July 24, 2018

Re: MMC Staff Parking Garage | 222 St. John Street | Level III Site Plan  
Response to Public Comments

TYPICAL HYDRANT ASSEMBLY DETAIL
N.T.S.

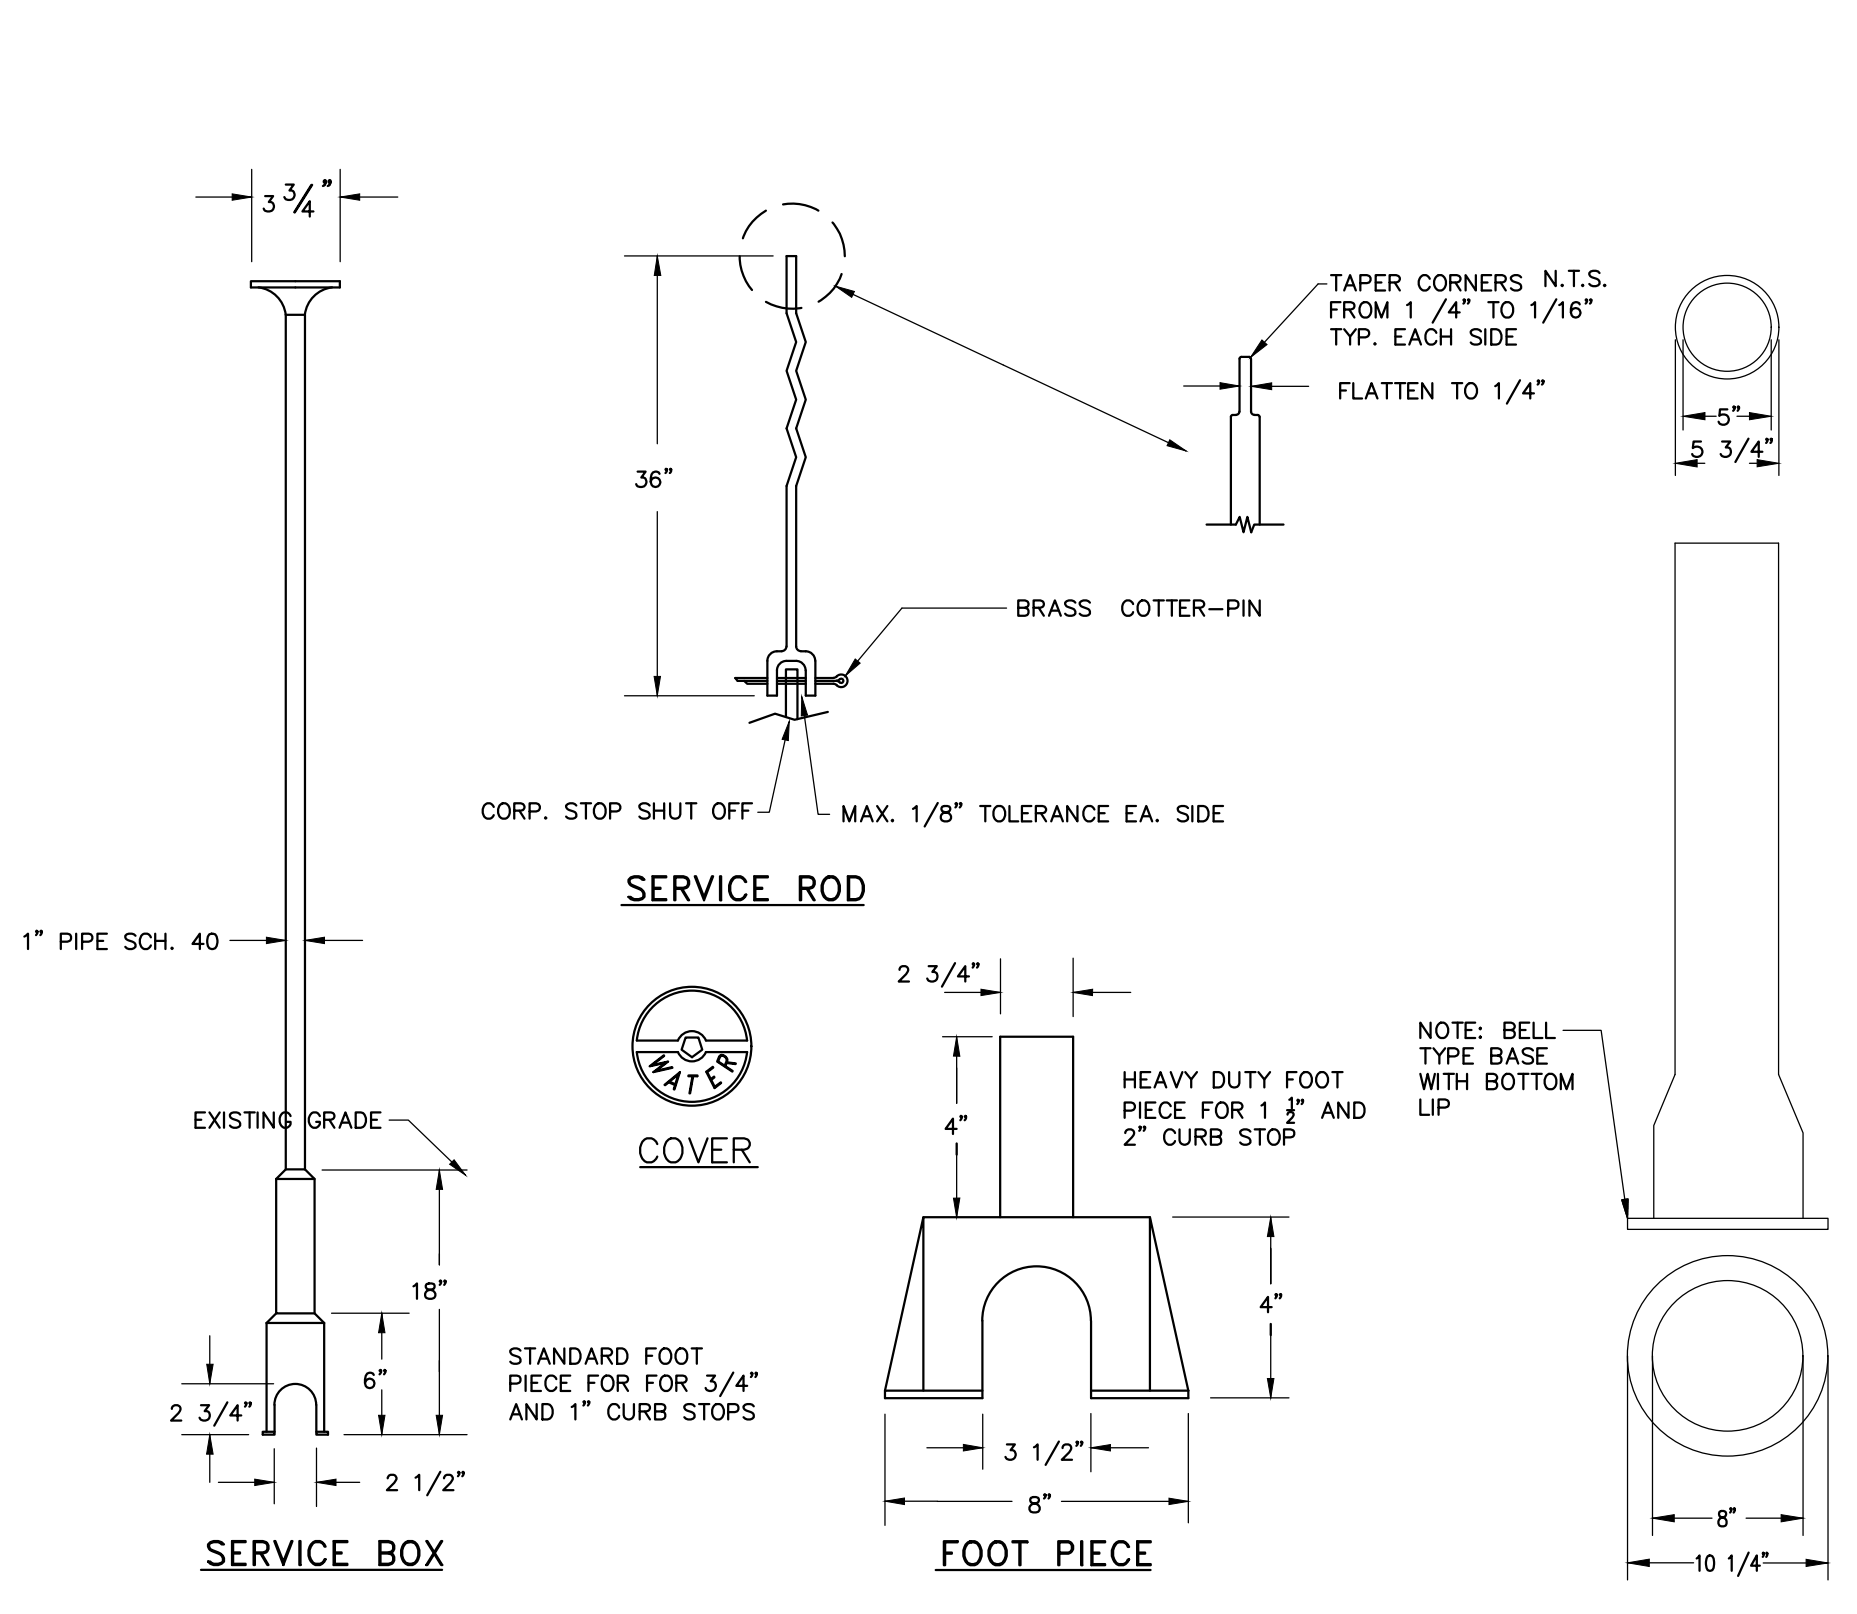
2. *A private fire hydrant will be required along the right side of the building, accessible from the lower parking lot.*

4. *There are sufficient public fire hydrants in the area, no additional public hydrants are required.*

**Response:** A private hydrant has been proposed adjacent to the garage entrance accessible from the lower parking lot. Please refer to the attached revised design drawings for the updated hydrant location.

**Response:** Acknowledged. As stated above, a private hydrant has been provided adjacent to the garage entrance accessible from the lower parking lot. Please refer to the attached revised design drawings for the updated hydrant location.

GRADING & DRAINAGE PLAN - 2

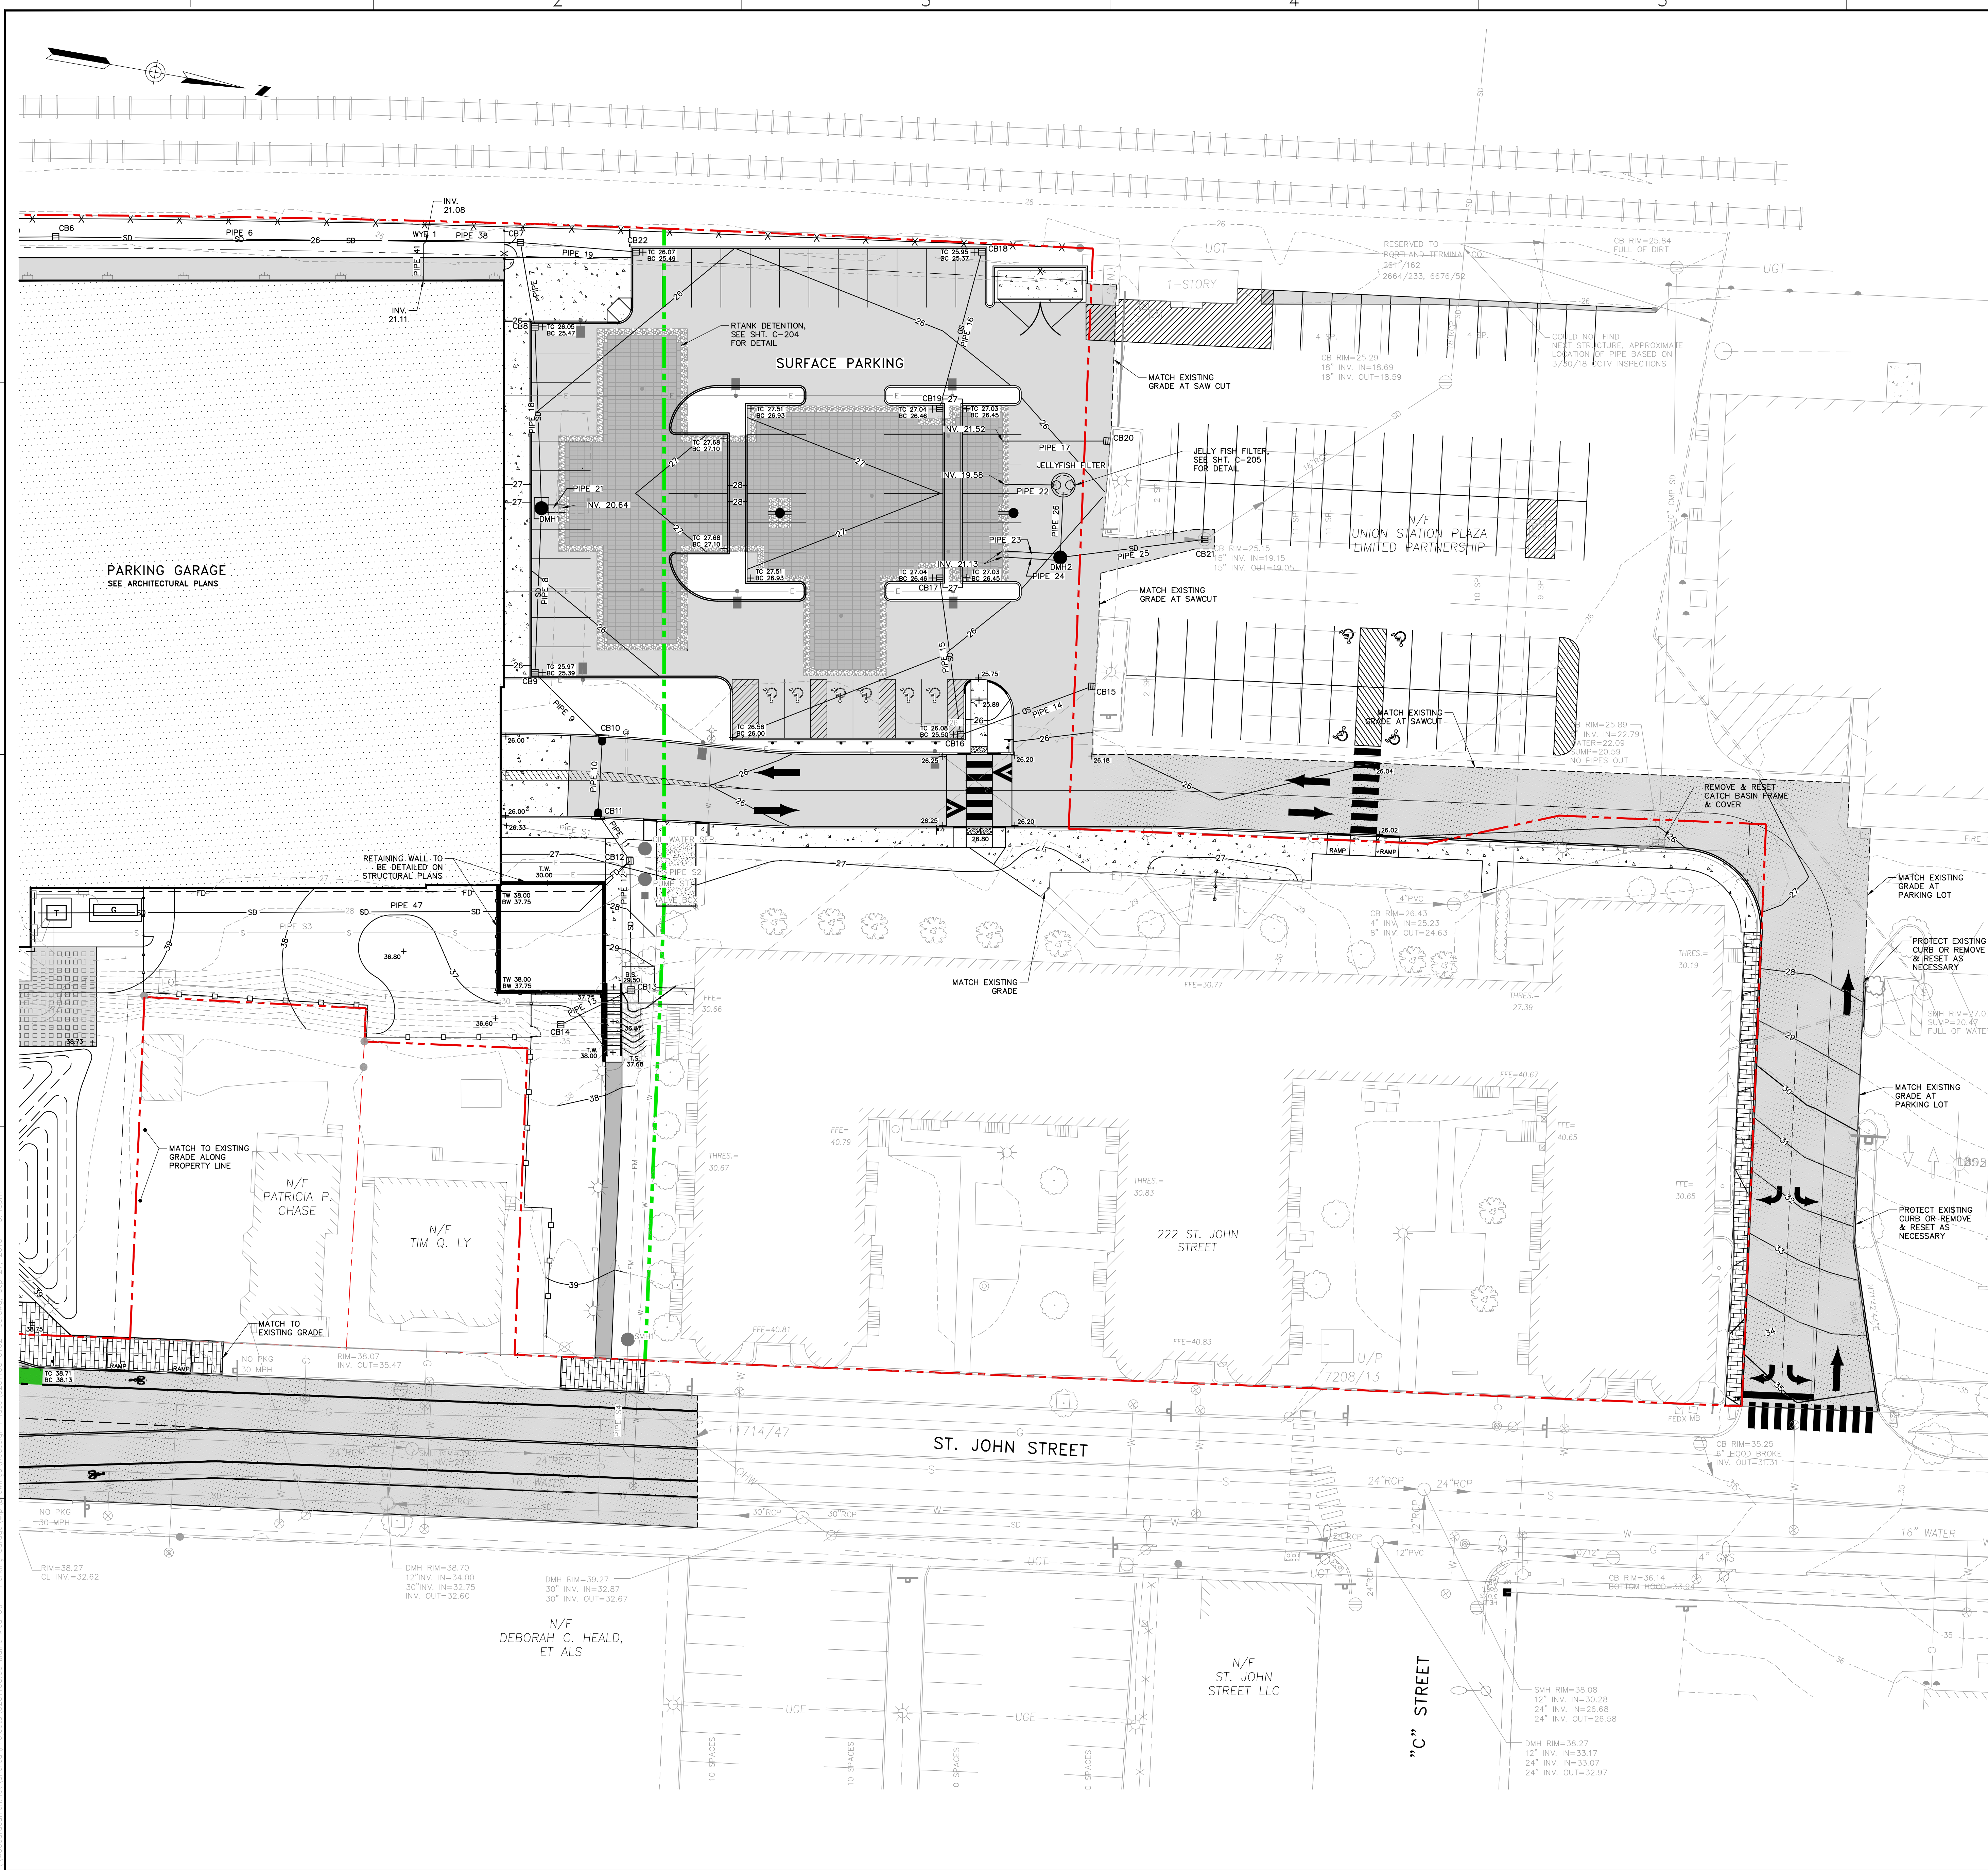
e. *CB12 has 1.37 feet of drop between the in and out inverts. Confirms this is the intended design or if the standard 0.1-foot drop is more appropriate.*

**Response:** Due to the large grade change from CB14 to CB11, a drop of 1.37-feet between inlet and outlet within CB12 was selected.

FABCO STORMBASIN, TYPE C FLANGE
N.T.S.

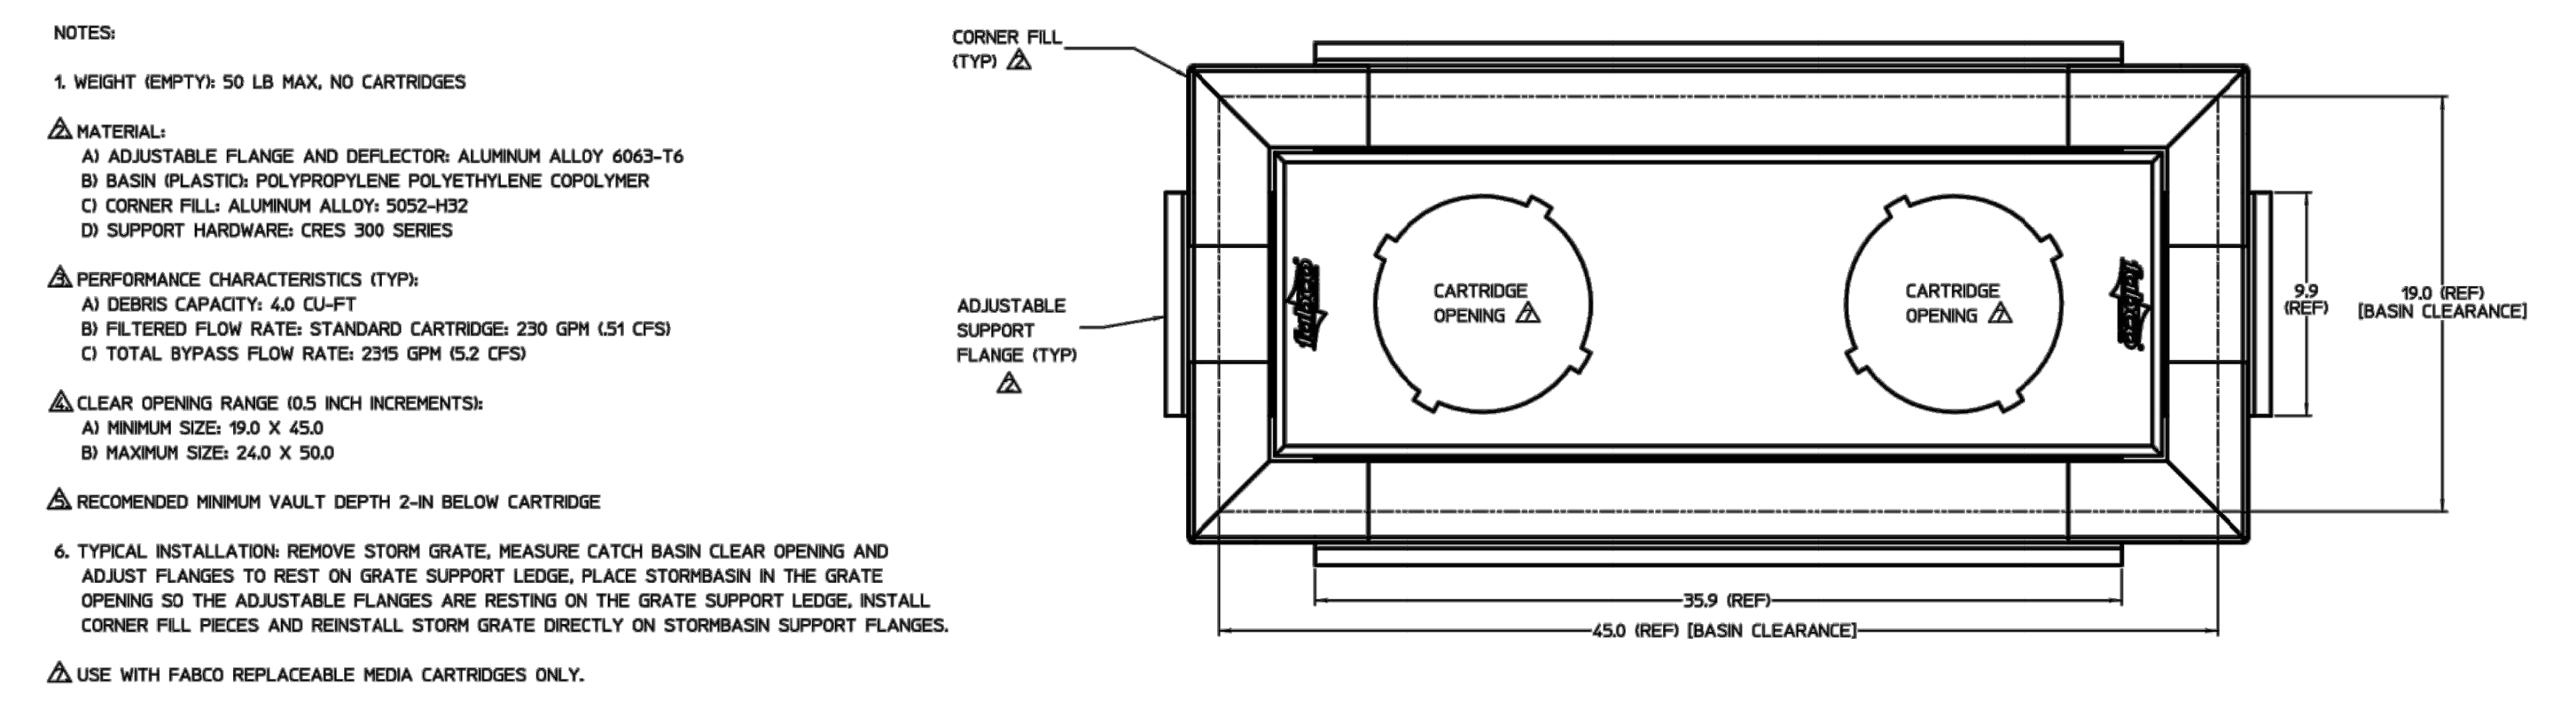
- a. *The StormBasin facility will provide a level of hydrocarbon removal, and removal of other pollutants from surfaces that convey surface drainage towards St. John Street. It is understood that this proprietary unit is currently not accepted as a stormwater treatment method under MaineDEP Chapter 500, but the applicant has provided information that Jellyfish Filter contains ample treatment volume to meet the City's Redevelopment Standard.*

**Response:** Comment acknowledged.
